From: David Wrigley [REDACTED]
Sent: 22 November 2024 14:32
To: Maya Cullen
Subject: 3/2024/0862 Higher Parsonage Farm
Attachments: Plans - 221124.pdf; Site Plan 7 - 221124.pdf

Following our recent telephone discussion regarding the LHA highways response dated 20 November 2024 please find attached a copy of the additional Site Plan 7 and a copy of the updated Plans both dated 221124.

SOUTH EAST ELEVATION

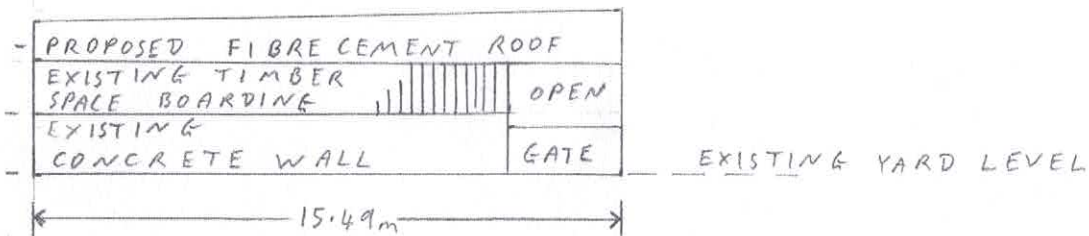
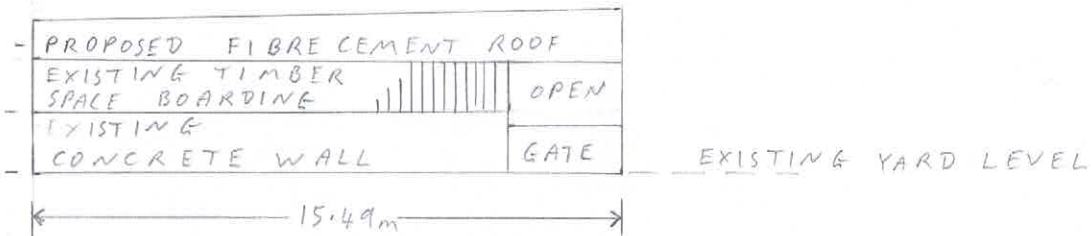
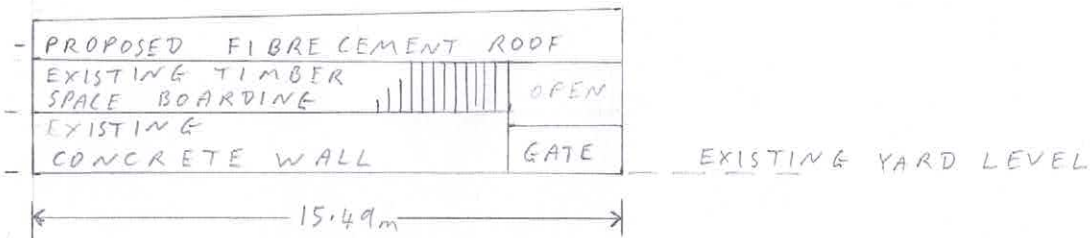
The amended Plans attached now show no new timber cladding on the south east elevation so providing adequate intervisibility between highway users and the agricultural vehicles using the existing site. The north east gable remains shown as cladded and does not impede any vision of or from any part of the road or sightlines. As stated previously the level of use and type of vehicle remain unchanged.
